# CITY OF ALBUQUERQUE

October 26, 2012

**Re: Garcia's Kitchen Food Prep and Catering Facility, 1736 Central Ave SW,  
Traffic Circulation Layout**

**Engineer's Stamp dated 10-03-12 (J13-D096)**

TRAFFIC CIRCULATION PLAN

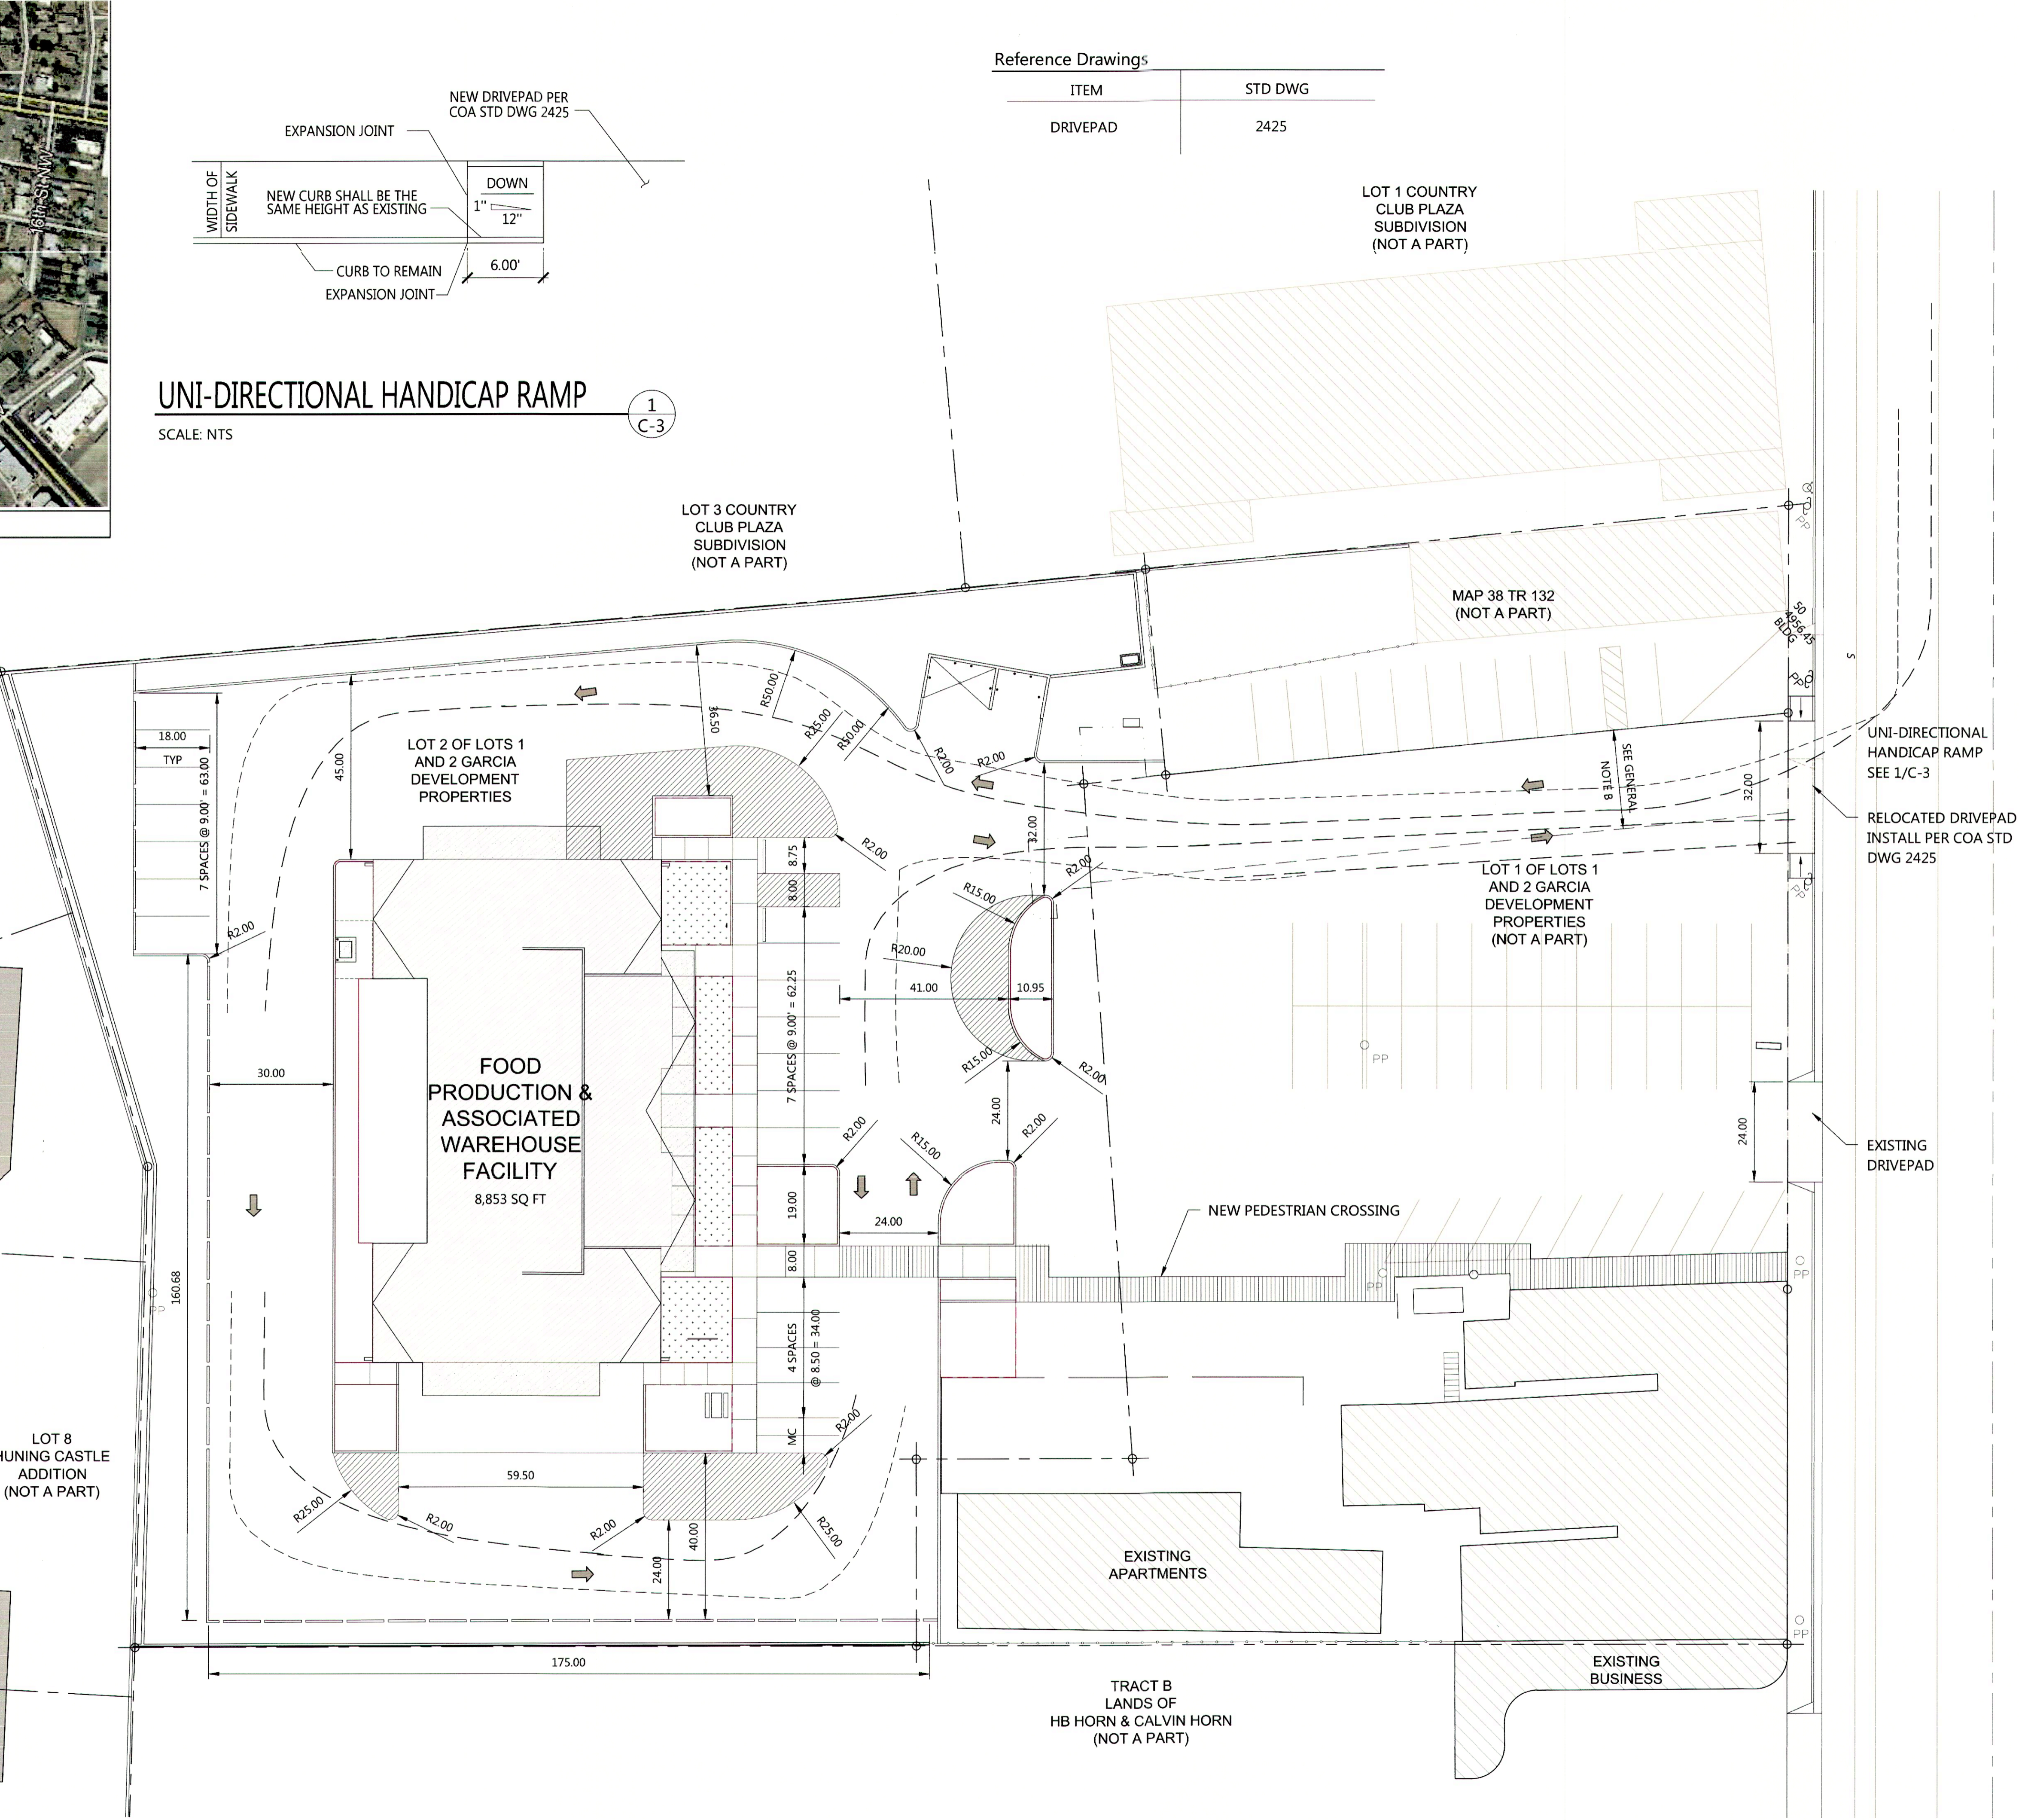
- A traffic circulation layout (TCL) must provide detailed geometric information (radii, dimensions, etc.) for a complete review. Existing conditions must be clearly differentiated from proposed conditions, and all easements and lot lines must be shown. Please review the TCL checklist attached to this letter.
